Todd Sherman
Design Built Homes, LLC
11400 SE 8th Street, suite 415
Bellevue, WA 98004

August 3, 2022

RE: Fire Alternative Request Letter - Permit Number 2207-122 – 8427 SE 47th Street

Permit Documents
Site Plan
A1

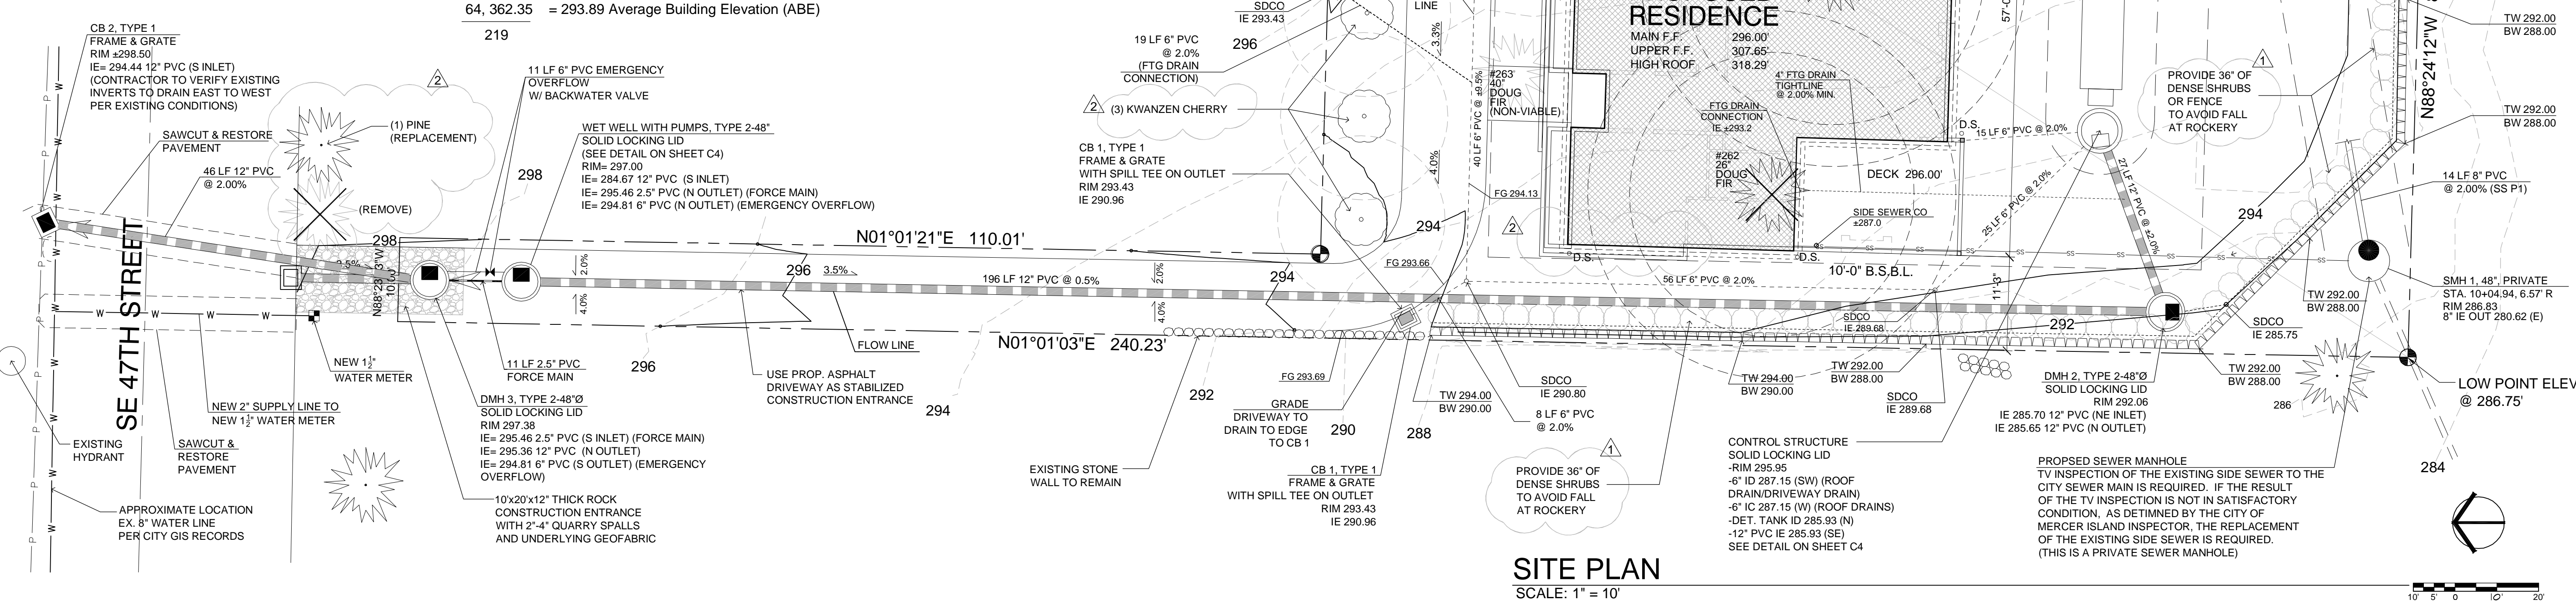
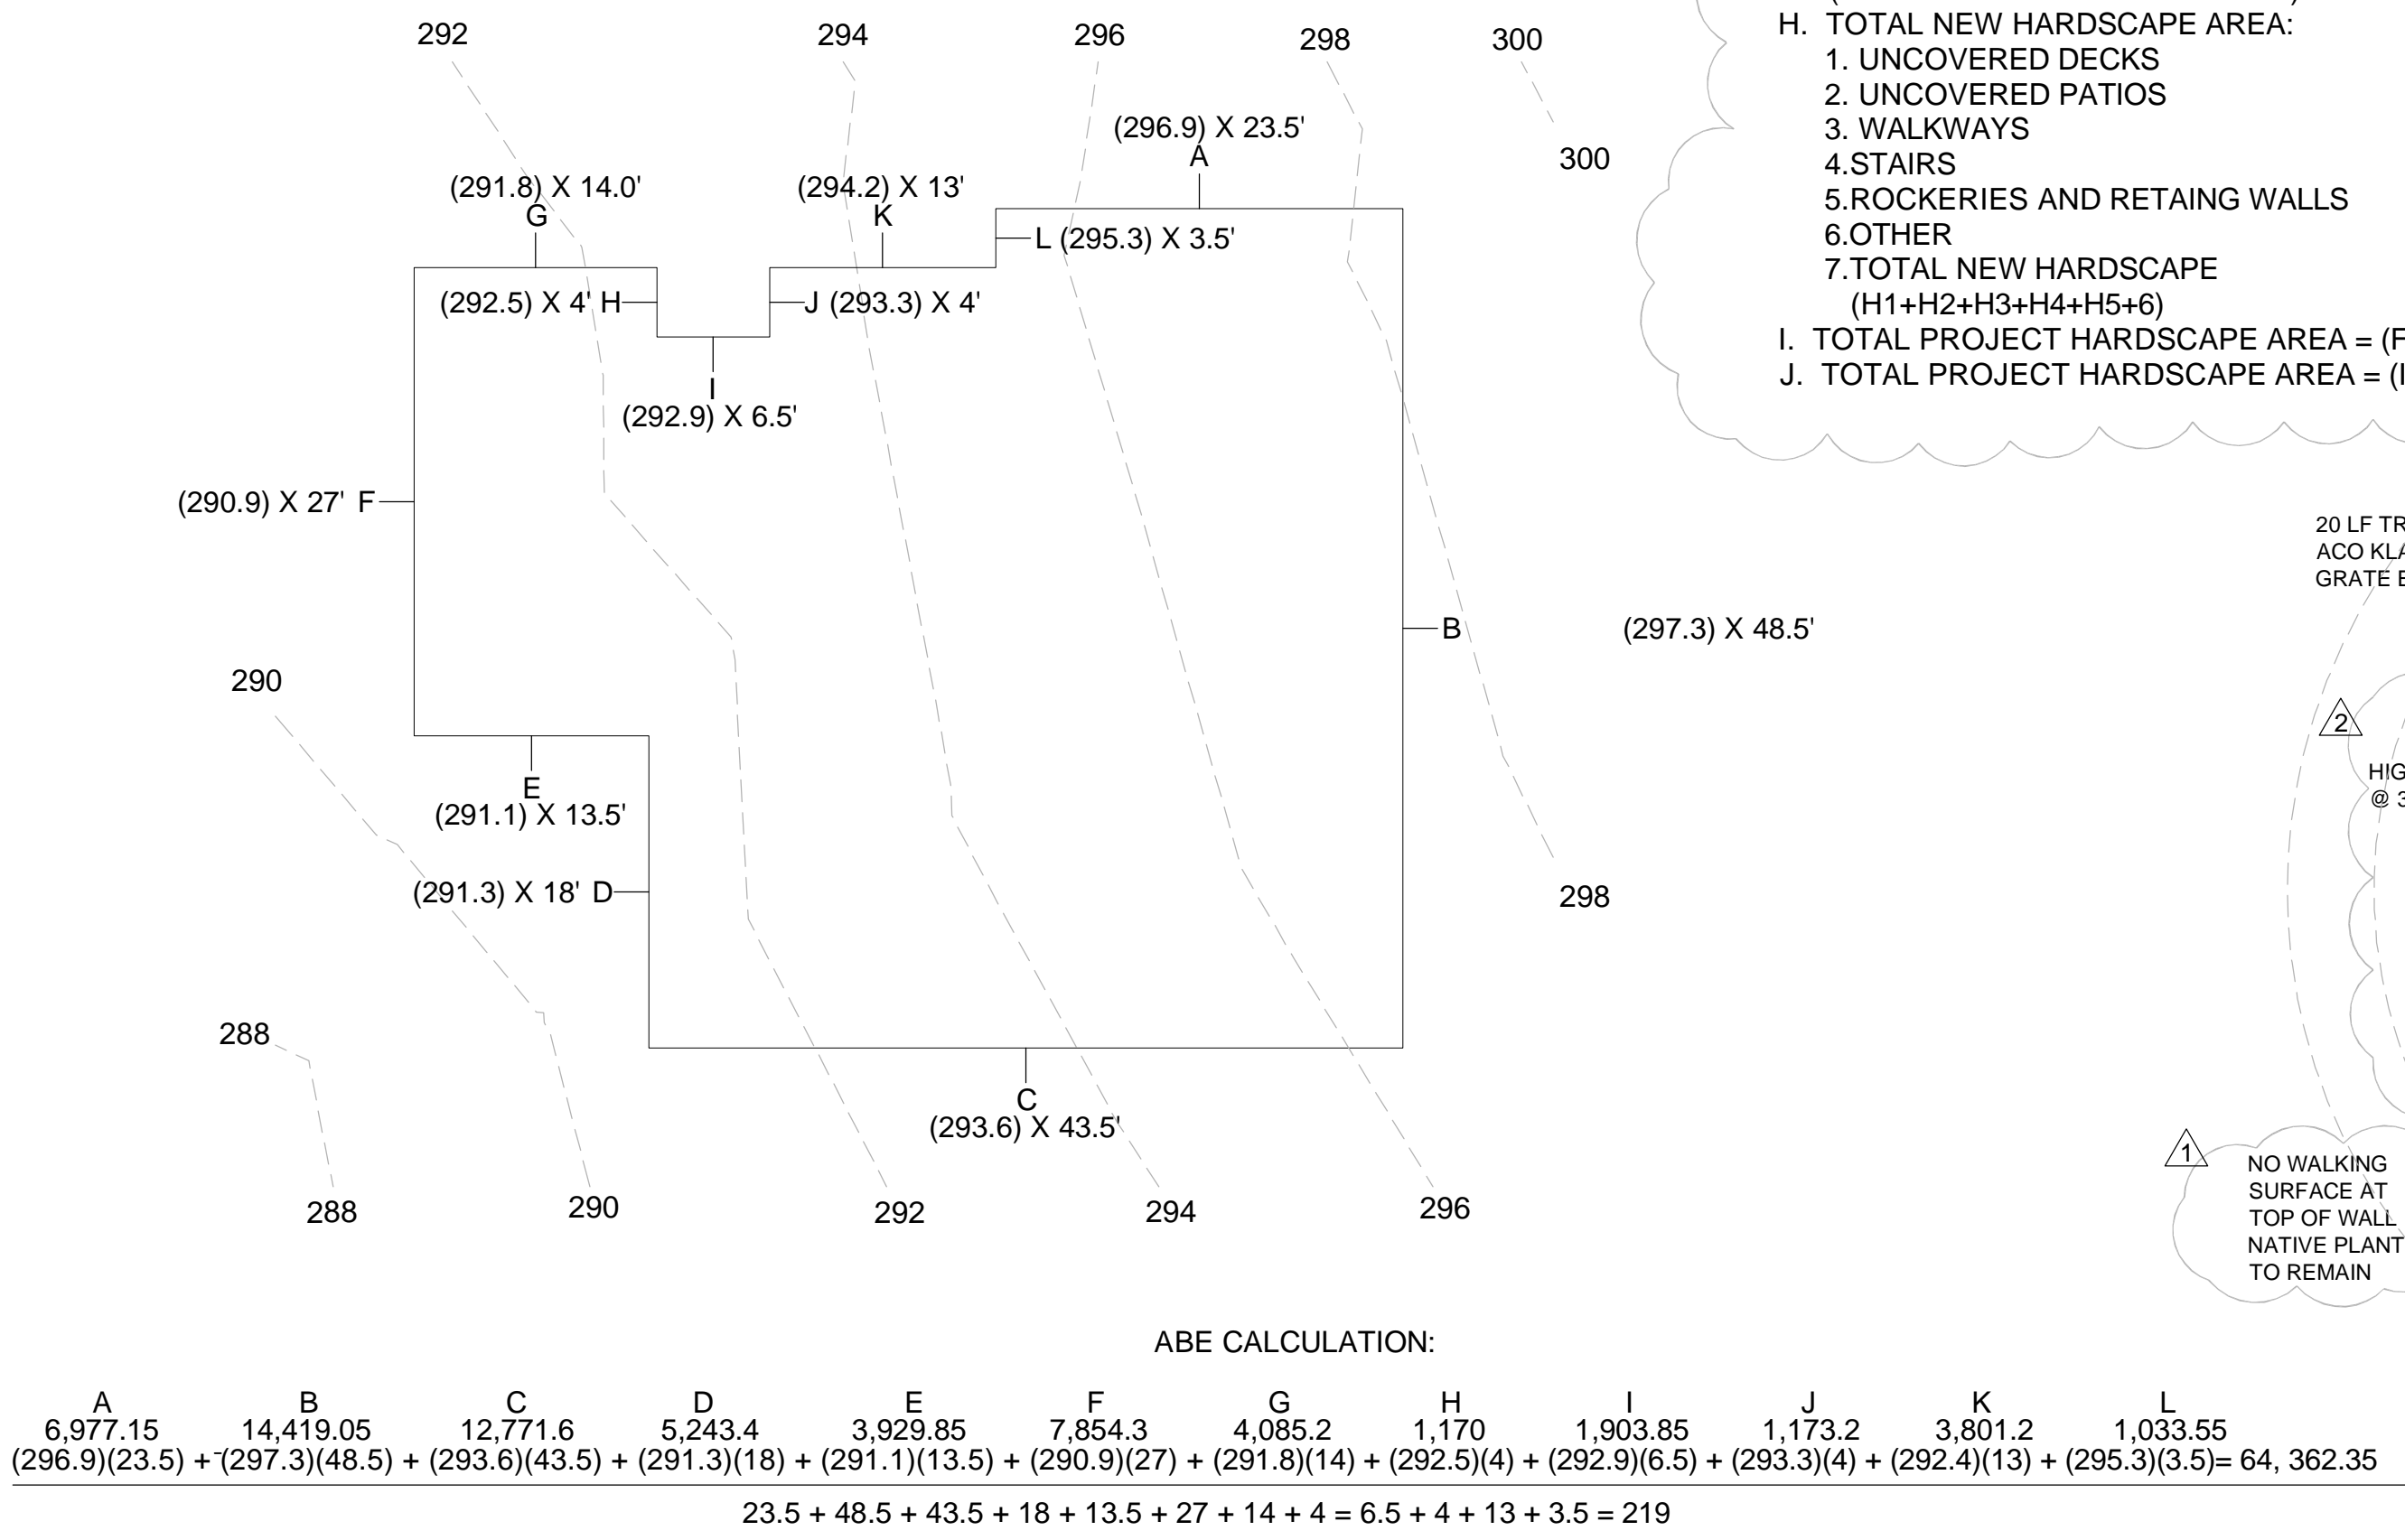
1. Fire flow is less than required (500 vs. 1000gpm w/ sprinkler)
2. No turn around
3. Access width is less than 20 feet (Under 12 feet CODE ALTERNATIVE REQUIRED)
4. Distance from fire access to rear of residence exceeds 150 feet (283 feet)

Due to this current lot and adjacent lots being platted years ago the current configurations cannot be changed or widened. The width of the driveway accessing the site will be 8 feet wide reduced because of the flag handle access property lines being only 10 feet wide, see A1 site plan. The flag handle is 110 feet from the property line to the front yard setback making the distance needed for fire access to the rear of residence unfeasible, see A1 site plan. Due to limited space being a unique flag lot with increased impervious area, challenging topography and lack of property access width a turnaround is not feasible.

1. Upgrade to an NFPA 13R- Plus sprinkler system
2. Installation of Household Alarm System per NFPA 72 Chapter 29
3. Install 1-hr rated gypsum at main and upper floor ceilings (All ceiling locations)
4. Provide solid core or fire rated doors
